**Subject: Upgrade to North Sydney Public School (SSD-11869481)**

Thank you for your email received 7 September 2021 requesting comments on the above proposal. Environment, Energy and Science Group (EES) provides the following comments in response.

Figure 2: Ground level plan of proposed development (Fulton Trotter, 2021)

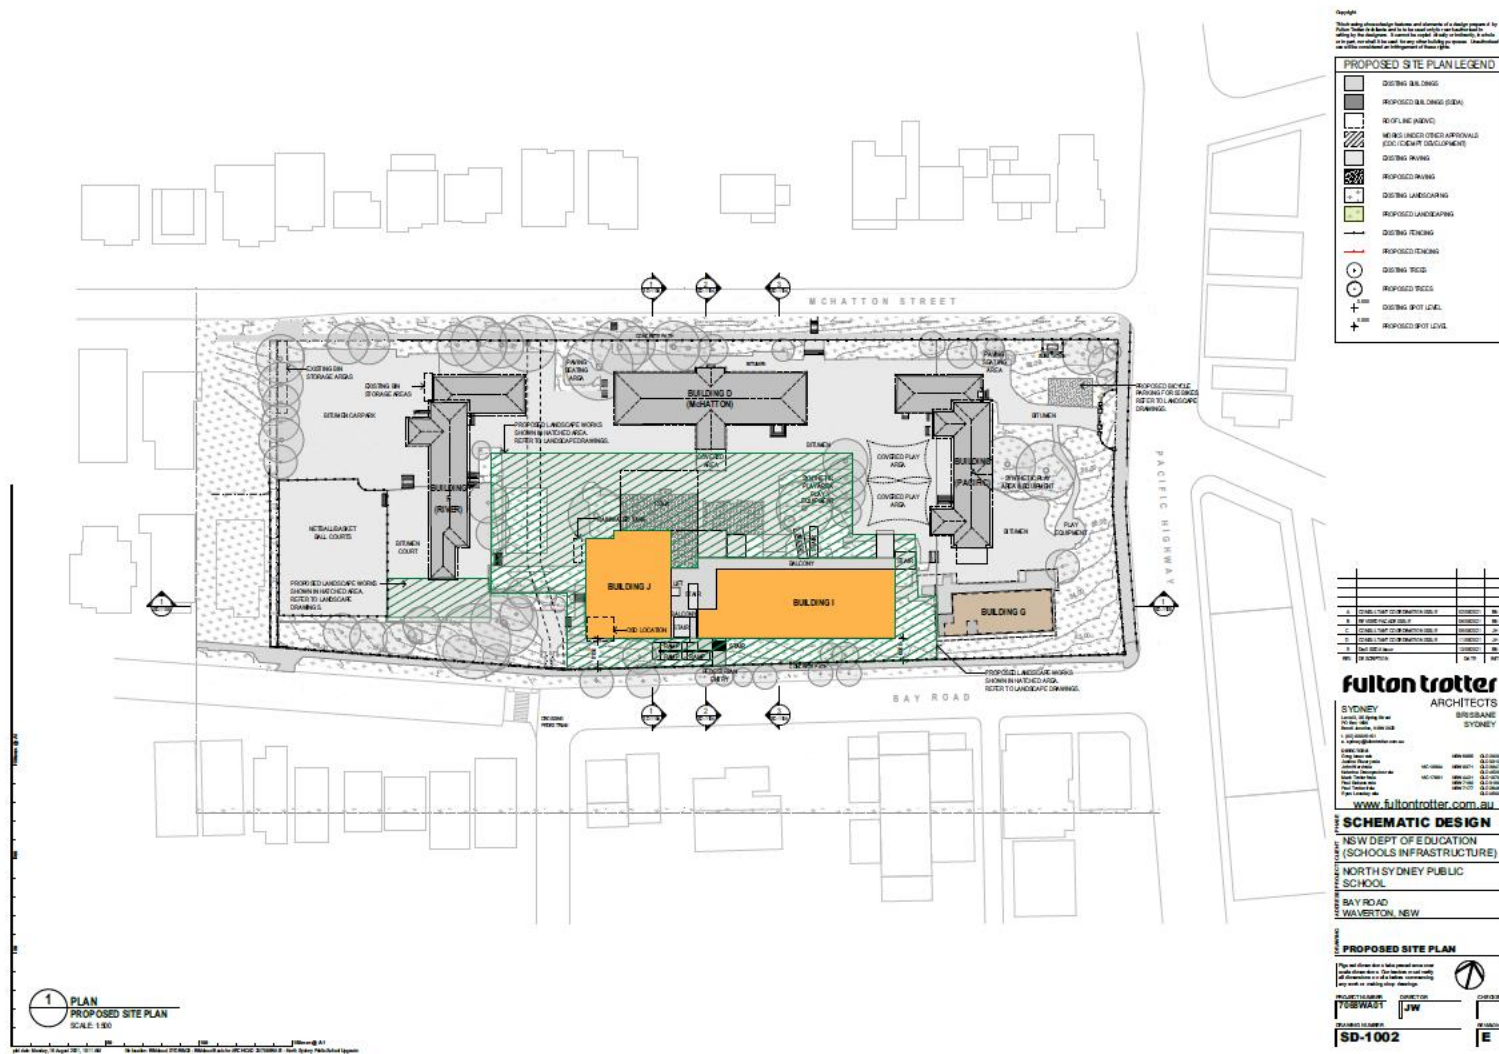
Although it is acknowledged that the amended building footprint is generally consistent with that identified in the waiver it must be specifically confirmed that the proposal (in its entirety) remains as described in Schedule 1 of the waiver. It must also be confirmed that the 0.06ha of proposed clearing is consistent with trees identified for removal in the Arboricultural Impact Assessment prepared by Arboreport dated 25 August 2021.
